Our Reference: SYD18/01322/25

Departments Reference: SSD 9522

RESPONSE TO SUBMISSIONS ADDENDUM - KEMPS CREEK WAREHOUSE, LOGISTICS AND INDUSTRIAL FACILITIES HUB (SSD 9522)

MAMRE ROAD

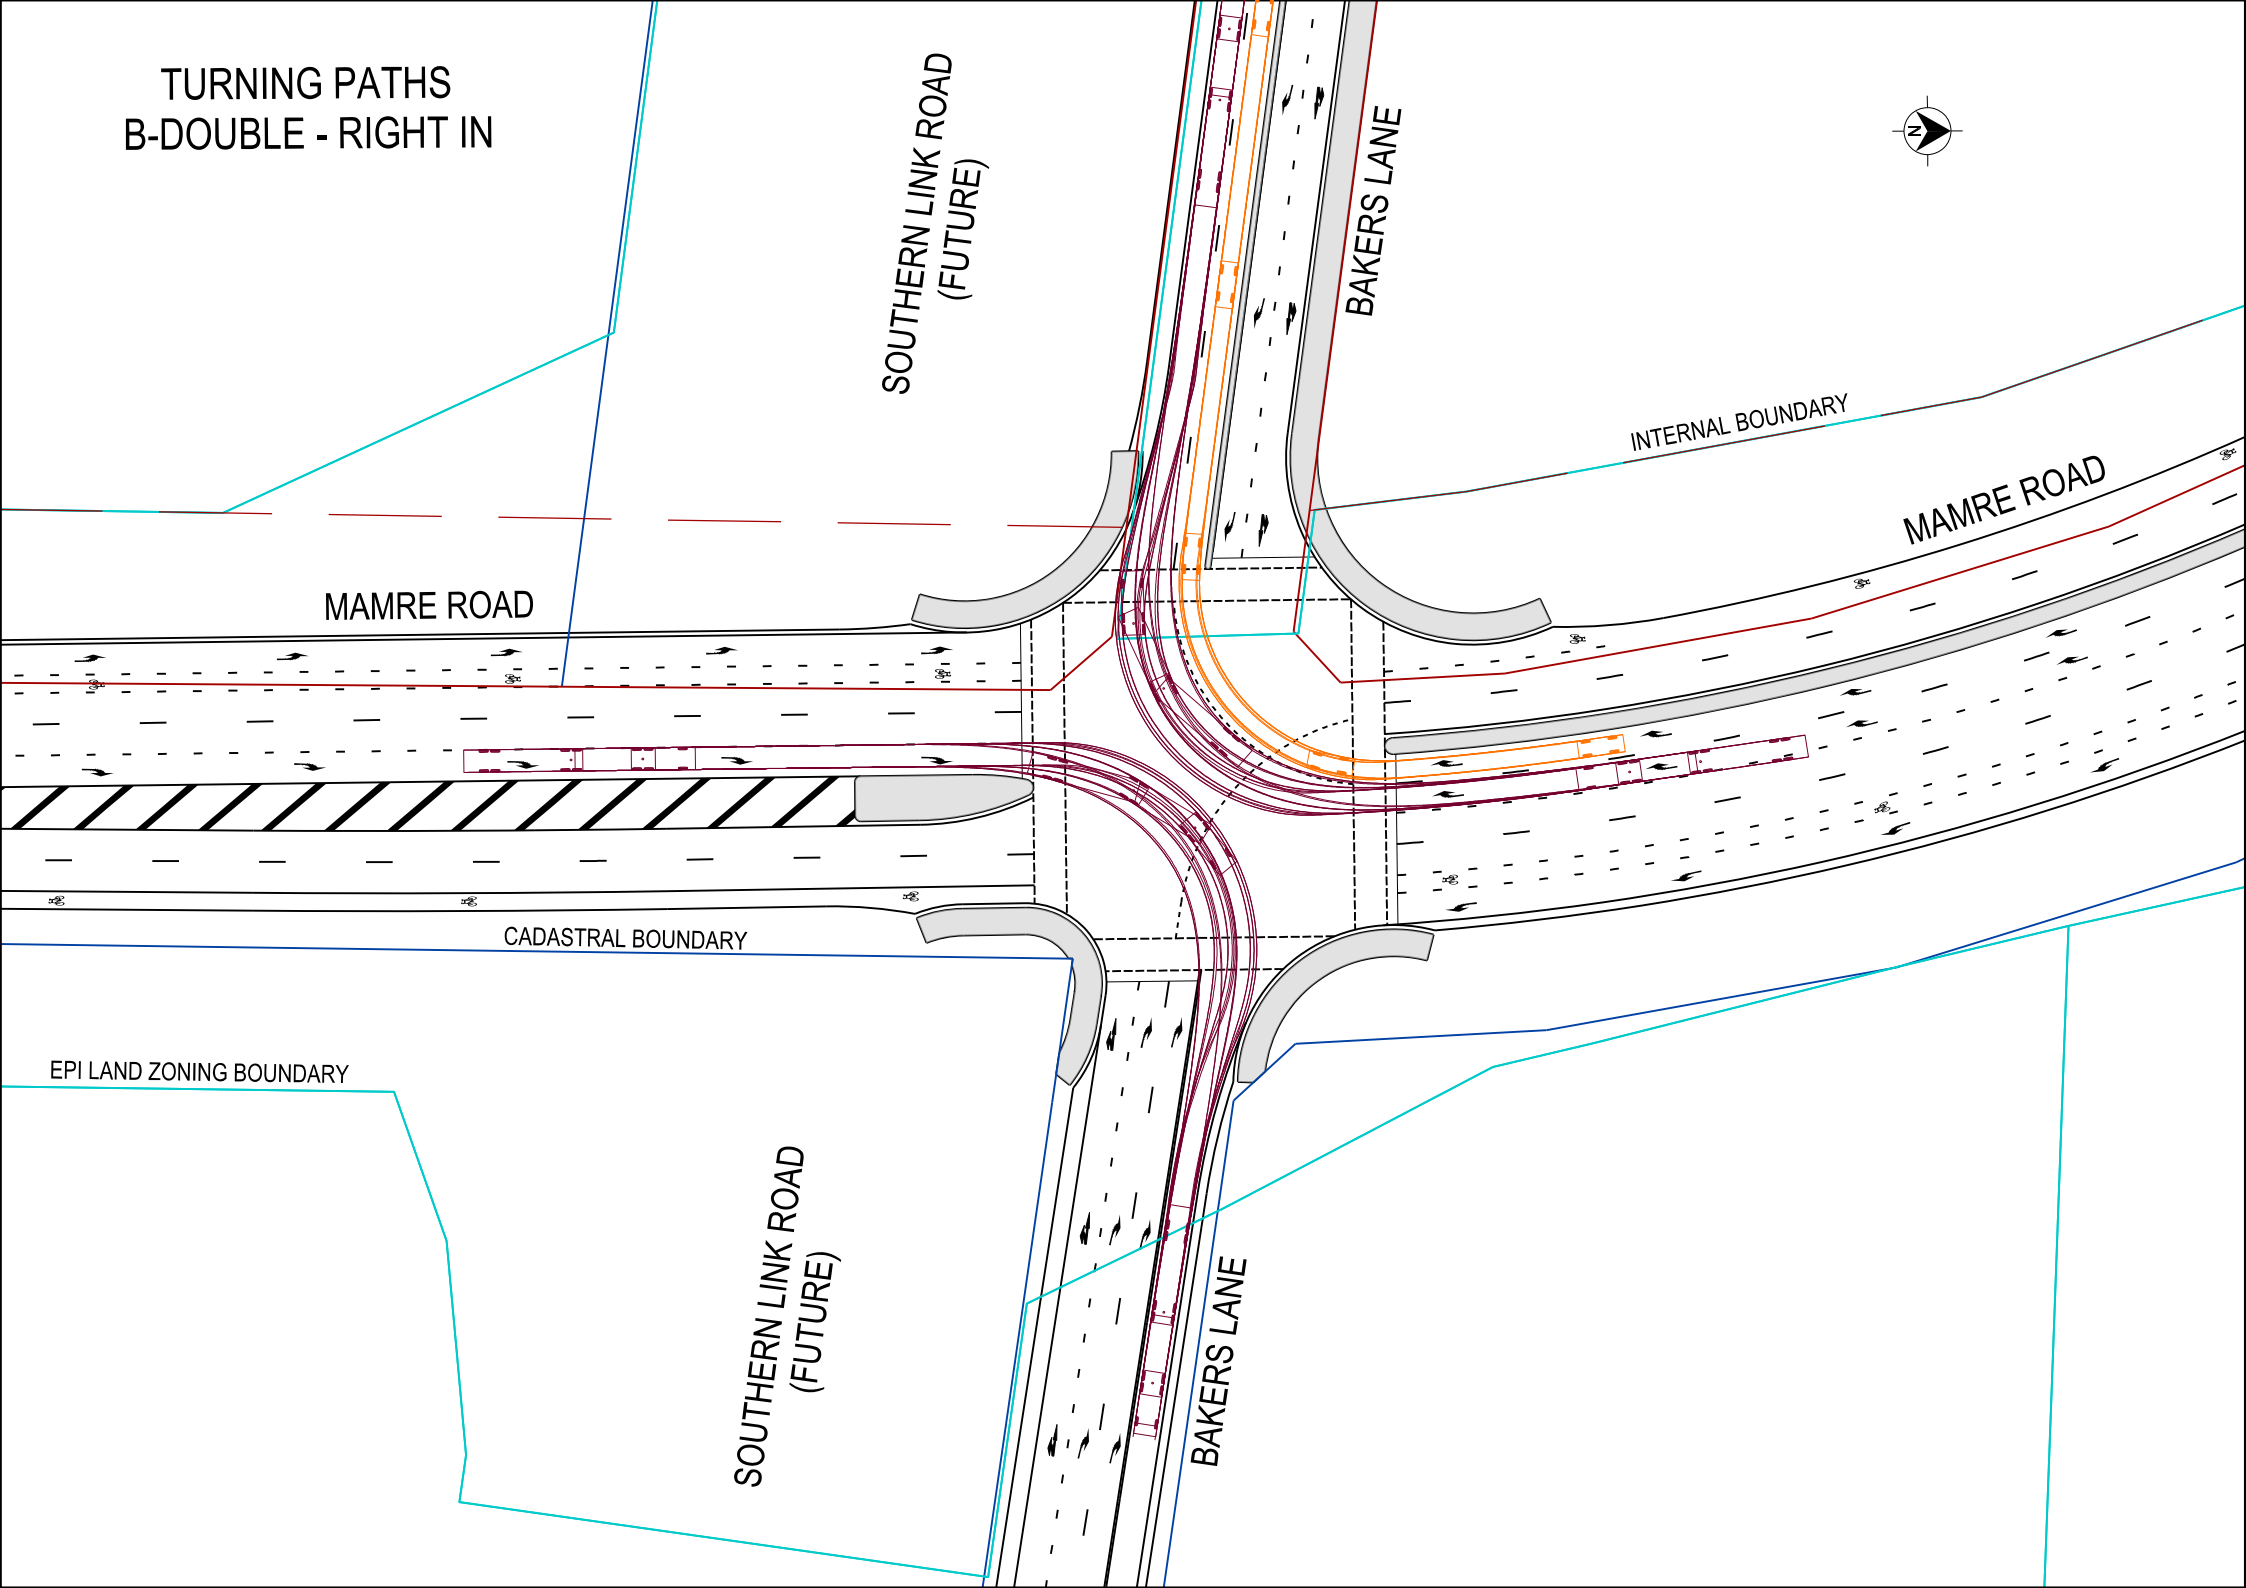
- The eastern section of Bakers lane is not a B-double route therefore the abovementioned design for the eastern leg accommodates for a 19 metre Semi-Trailer with a checking vehicle of a B-double. An A-double cannot be achieved and will require further upgrades to the signalised intersection should the eastern section of Bakers Lane be changed to a B-double or A-double route to accommodate future developments to the east. This is not provided under this development application which is located on the western side of Mamre Road;
